**From:** Bloomer, David [<mailto:David.Bloomer@lancashire.gov.uk>]  
**Sent:** 30 August 2016 09:21  
**To:** Adam Birkett  
**Cc:** LHS Customer Service; planning  
**Subject:** app3/2016/0715 Land Adj former Genus Site Mitton Road

Whilst I would raise no objection to the proposal on highway grounds, I would make the following comments regarding the application as submitted which need further clarification / information

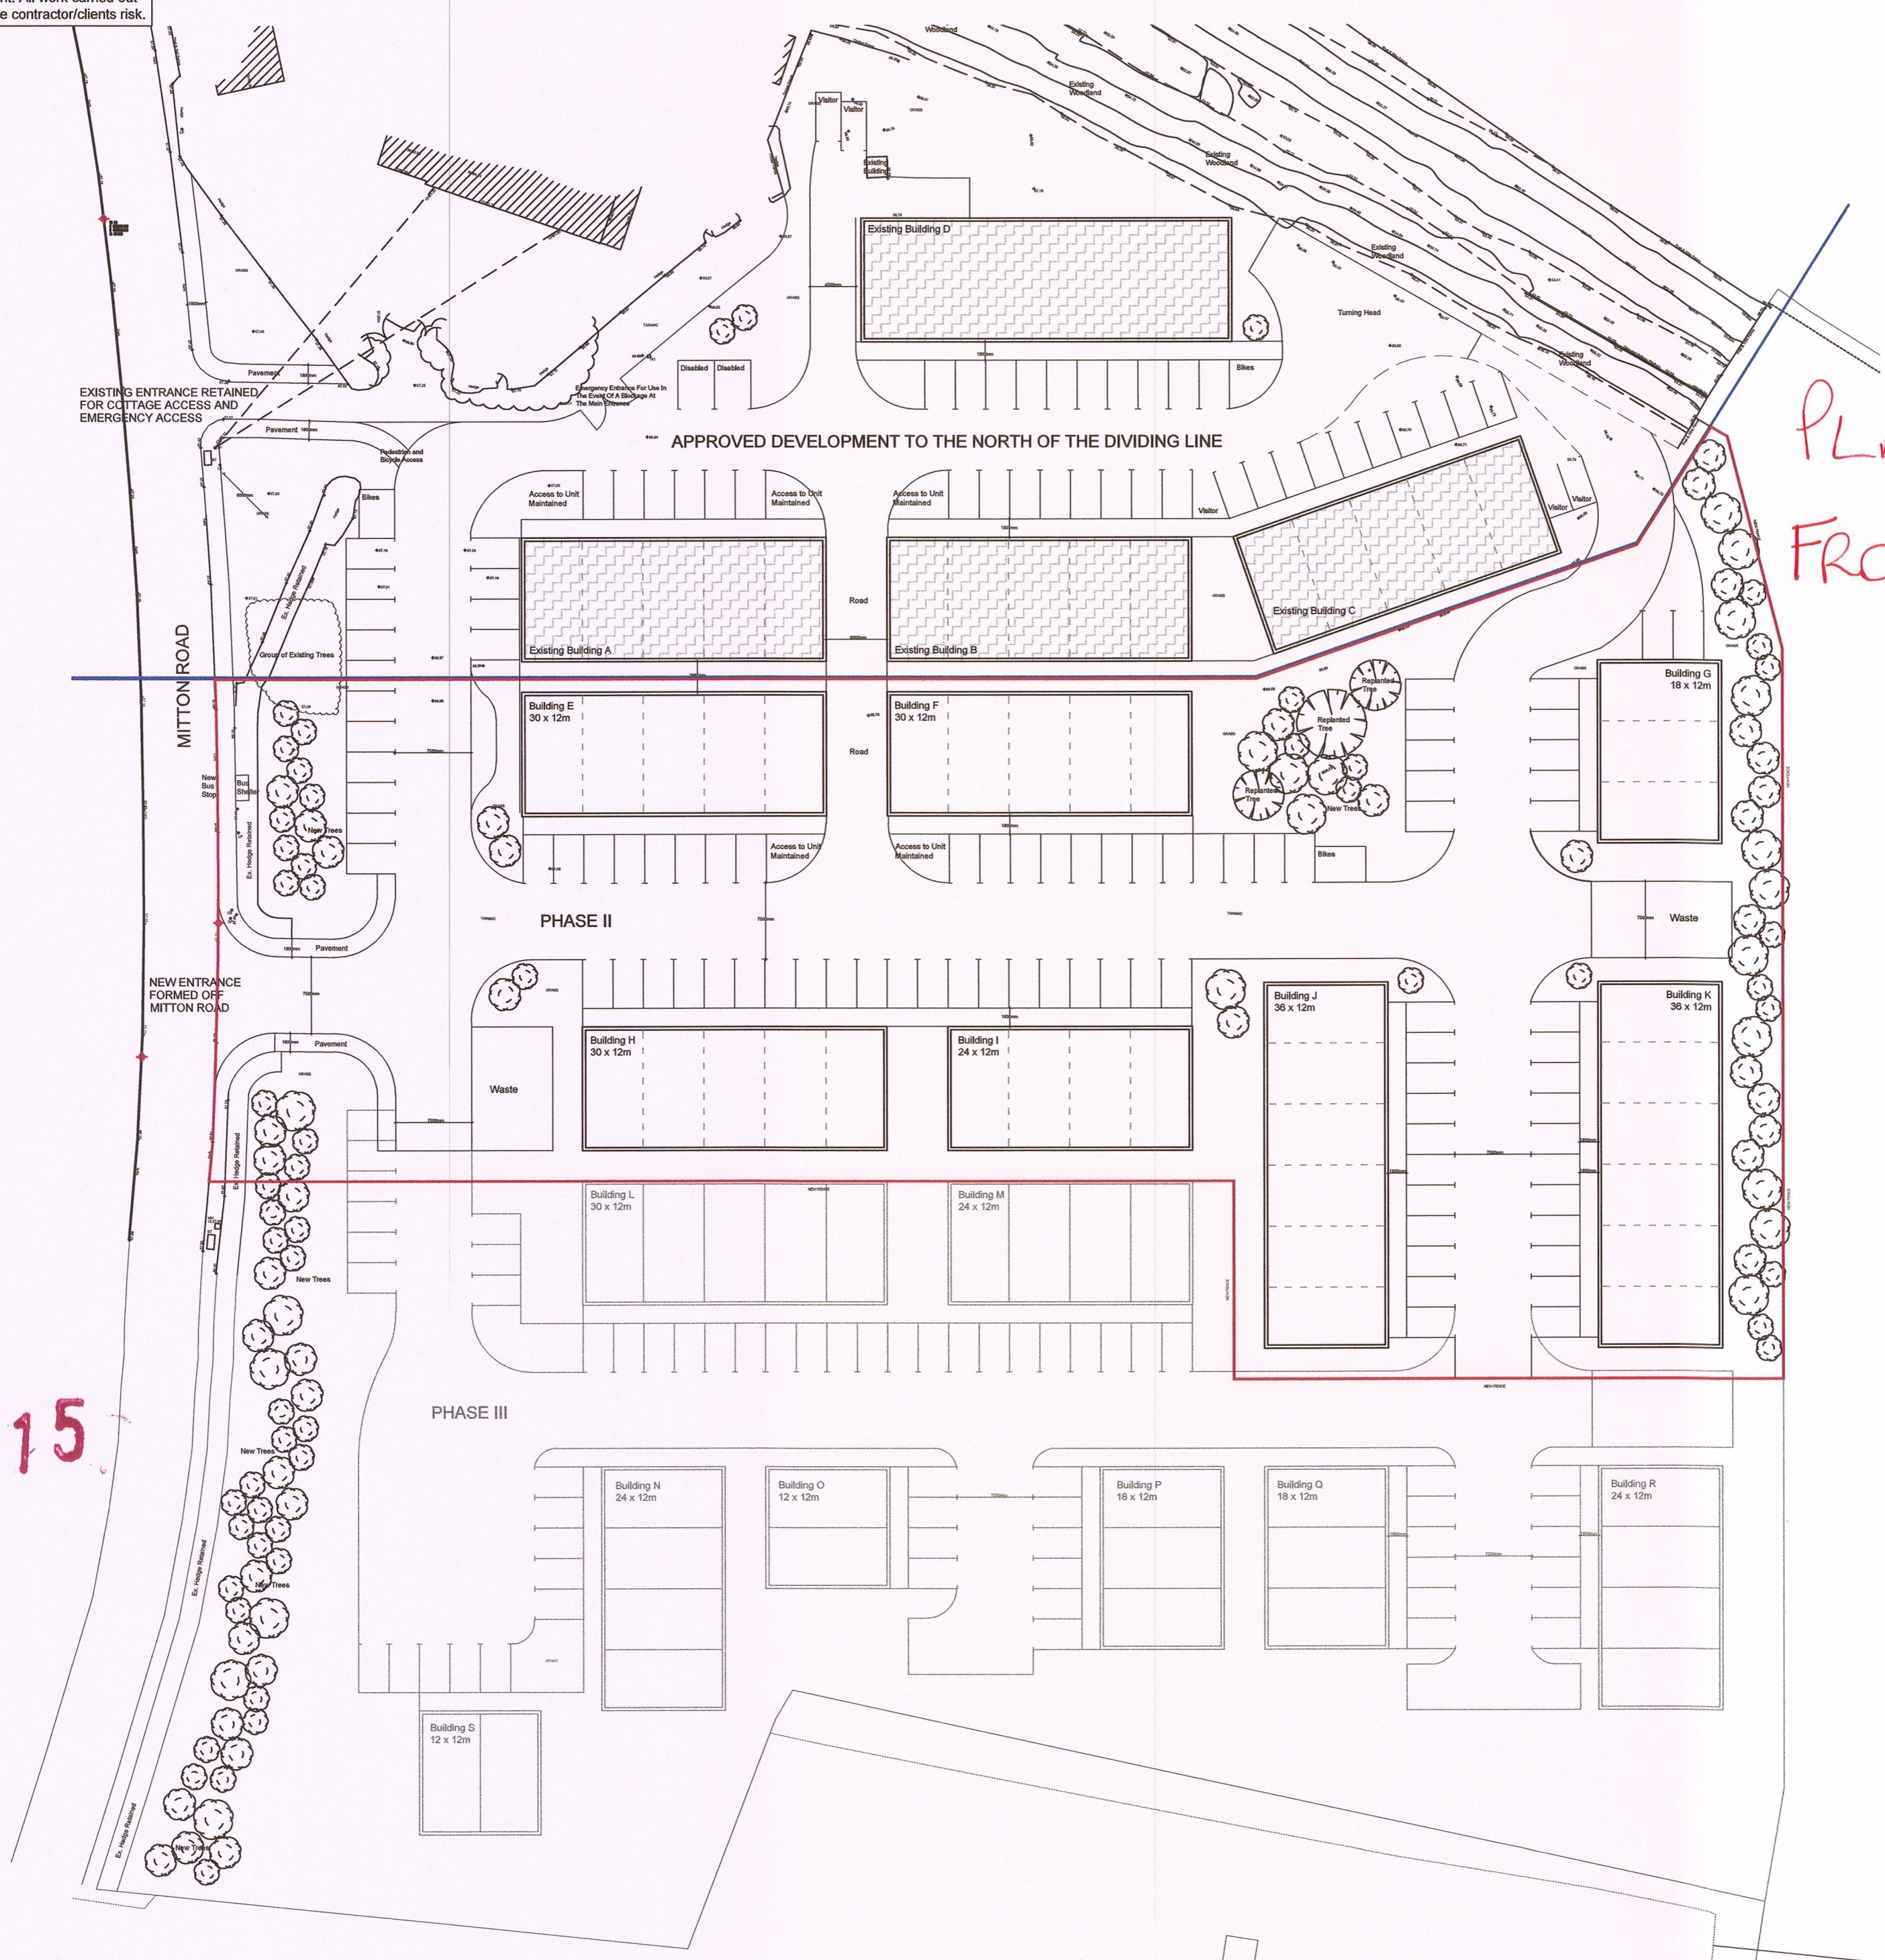
1 The proposal does not indicate what sightlines will be provided from the new access. The most recent traffic count undertaken by LCC ( Sept 2014 indicates 85<sup>th</sup>ile speeds of 40mph and 36 north/southbound respectively) which would equate to sightlines of between 2.4m x 90 – 120 m (Design Bulletin 32).

2 The existing access is to be retained for the 2 cottages and an emergency access, no indication is given as to the method to be employed to prevent unintentional use.

3. A footway should be provided between the existing and proposed access and also for a short length to the south of the proposed access.

4 The proposed bus shelter (if required) will sit within the sight line.
